Town & Country Planning Act 1990 (as amended)
Town and Country Planning (Development Management Procedure) (England) Order 2015
Approval of matters reserved by condition imposed under BE/18/17/PL relating to conditions 4-archaeological works, 5-surface water drainage, 9-landscape scheme, 10-protection of existing trees/bushes/shrubs, 14-foul drainage, 15-ecological enhancement scheme, 17-landscape management plan, 18-details of laying out timetable for provisions & future maintenance of Public Open spaces, 20-10% decentralised & renewable or low carbon energy sources, 21-street lighting scheme, 23-vehicle access, 25-car parking spaces, 27-construction of road(s), footways & casual parking areas & 28-Travel Plan statement.
Land West of New Barn Lane Bersted,,

Arun District Council have decided to **REFUSE details reserved by condition for the following reasons:**

The application to discharge Condition 5 imposed under reference BE/18/17/PL is refused by virtue of insufficient detail. The following detail is absent from the submission and should be incorporated as part of any future application to discharge this condition:

CONNECTION TO HEADWALL FOR DRAINAGE DITCH
SCALE 1:20

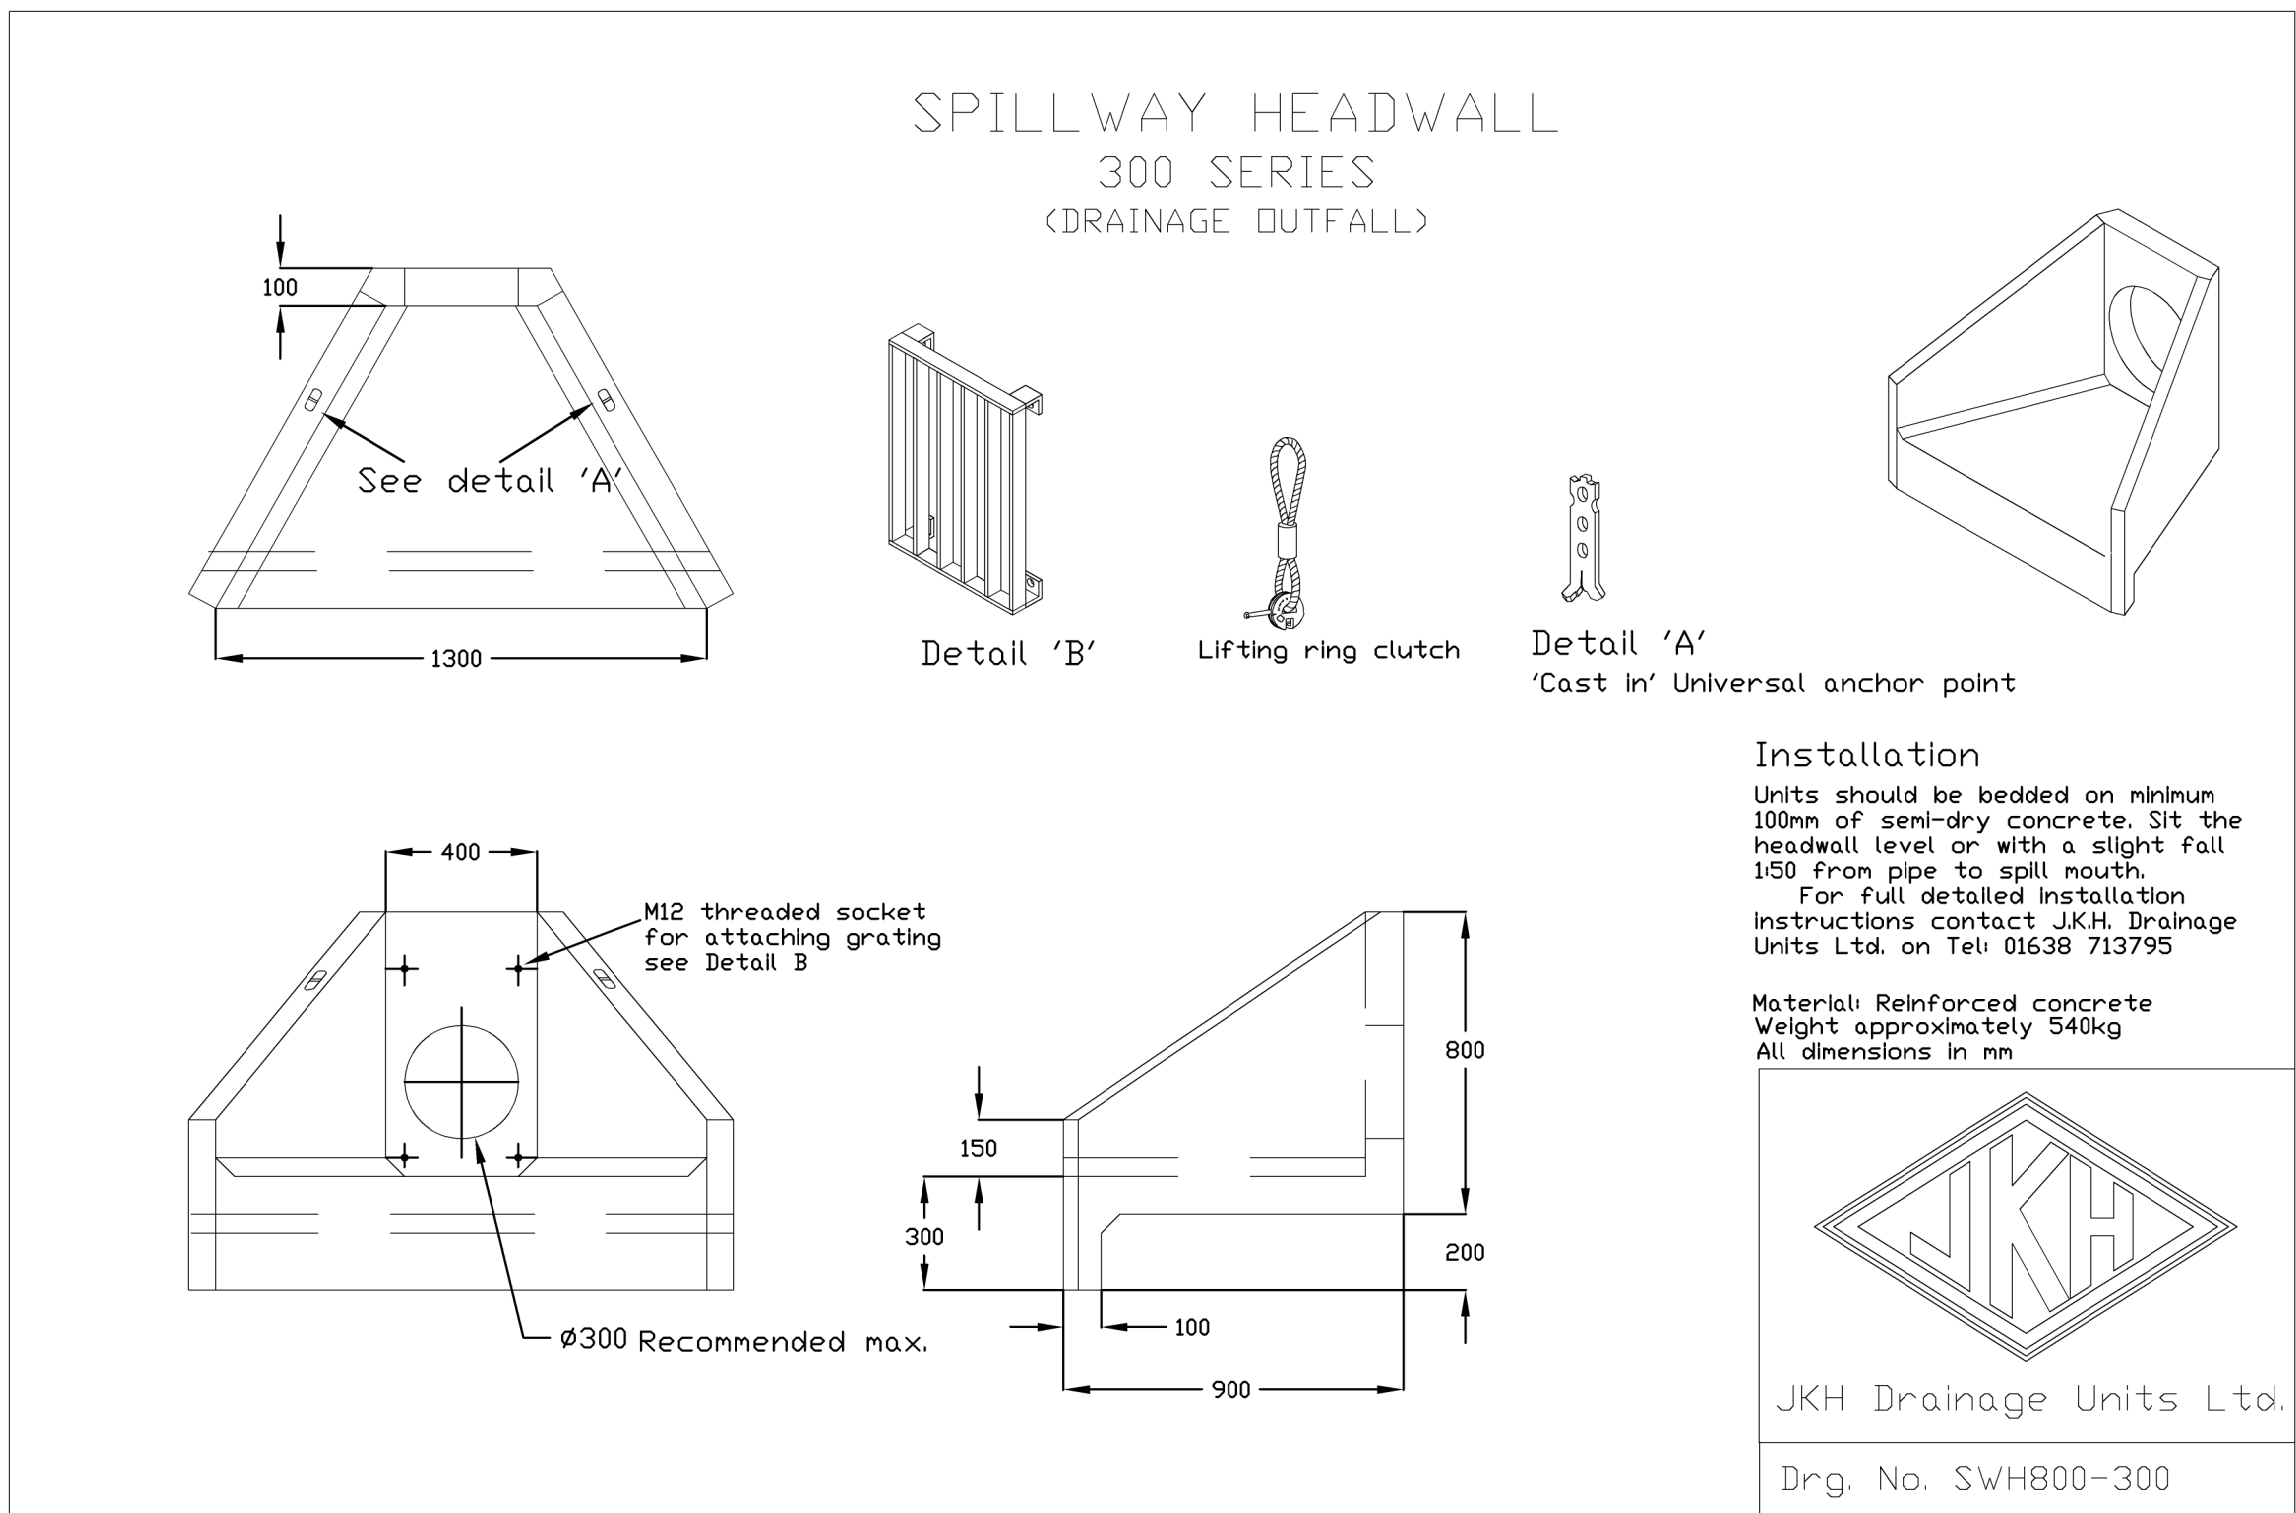
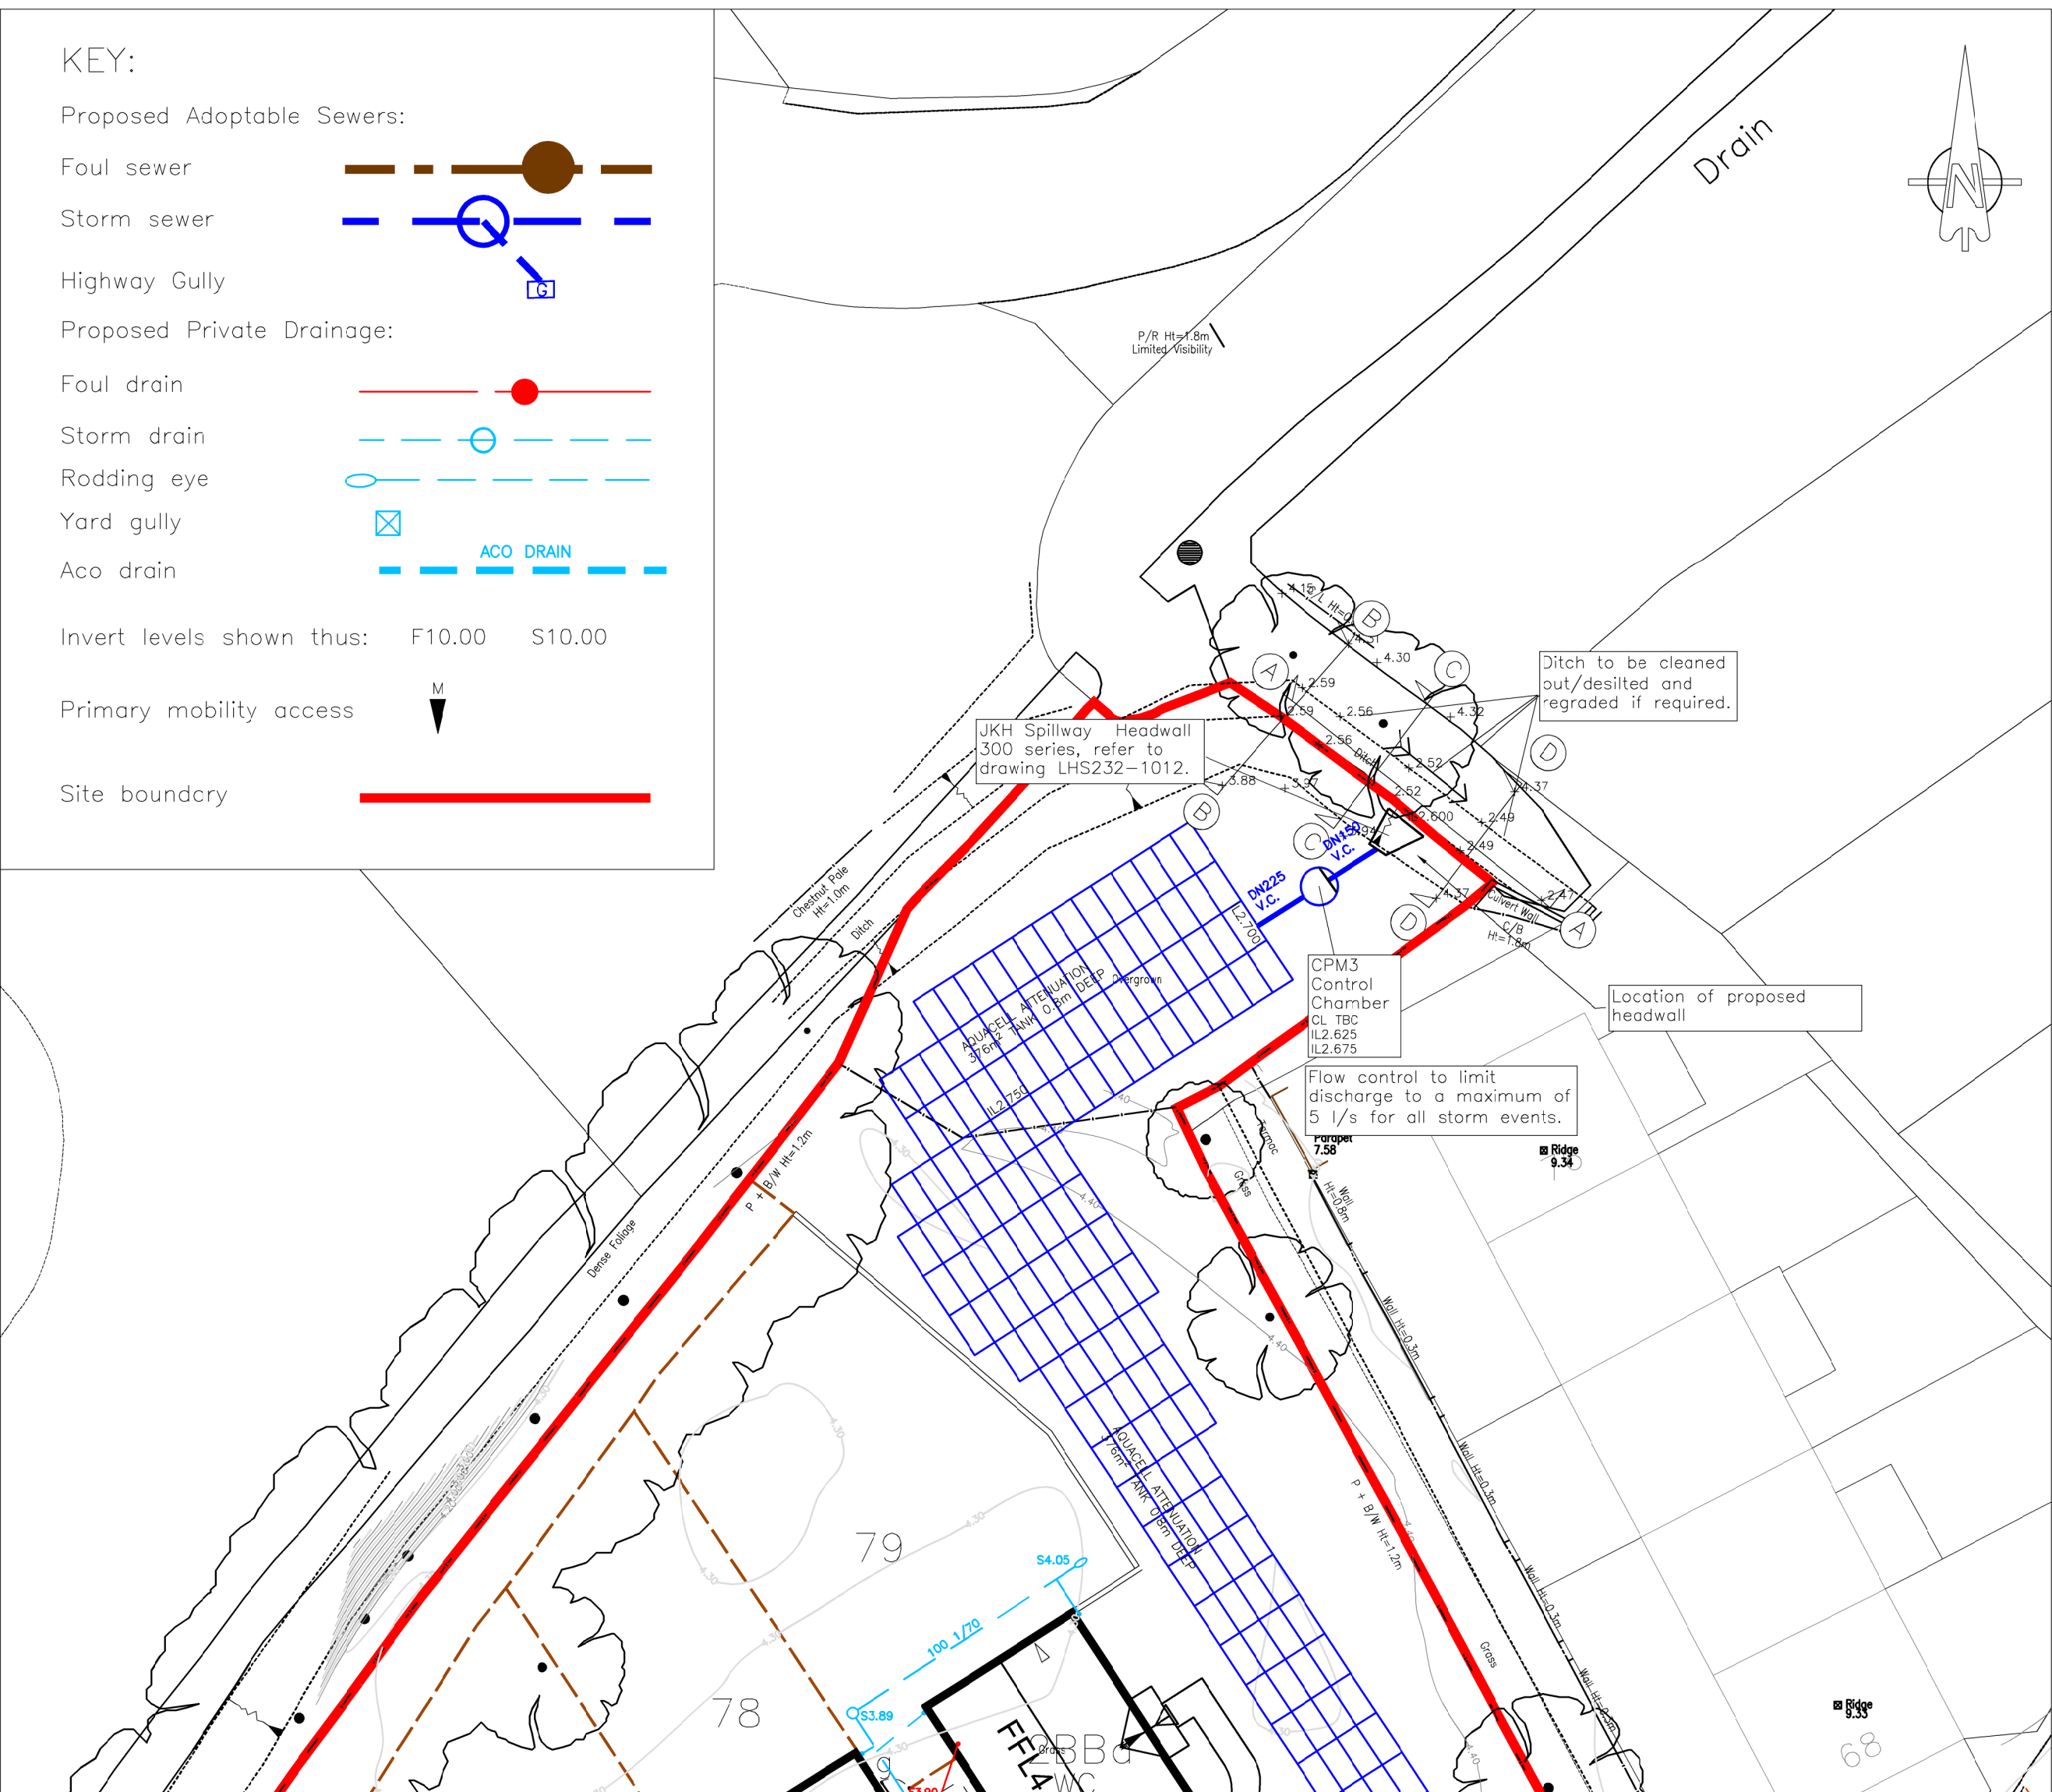
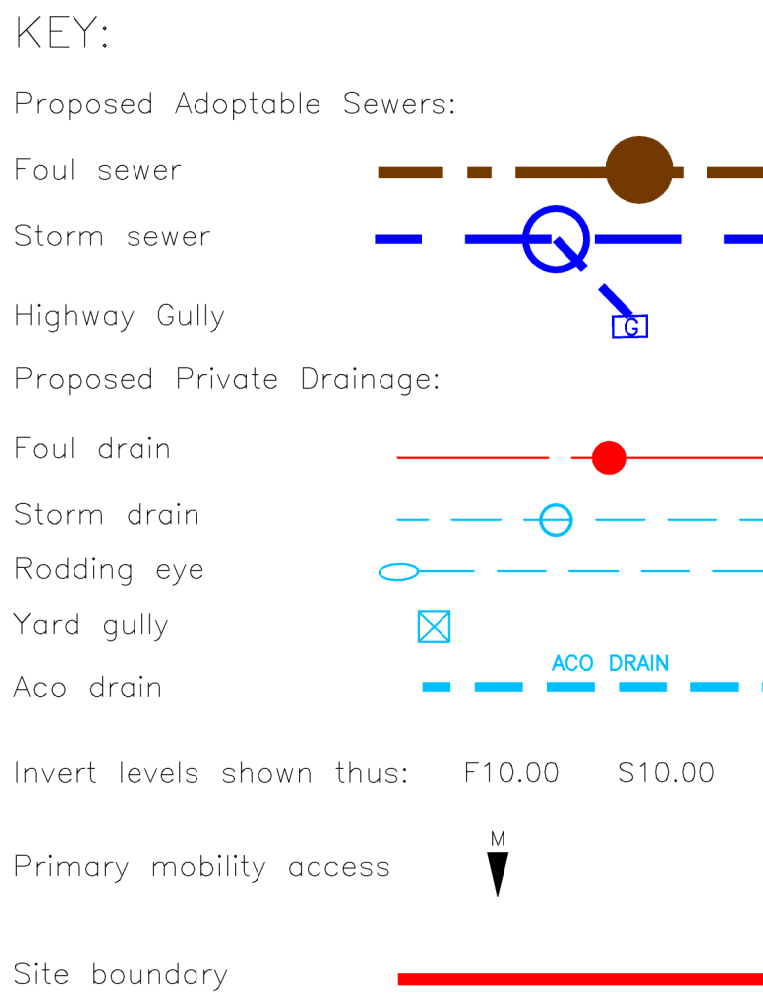
- Headwall details have been provided, however since this time it has become apparent that water voles are present within the ditch. Additional information is required establishing the methodology that demonstrates how these works will be carried out without damaging water voles and their habitat. Piped invert levels must be set 300mm above the bed level of the ditch.
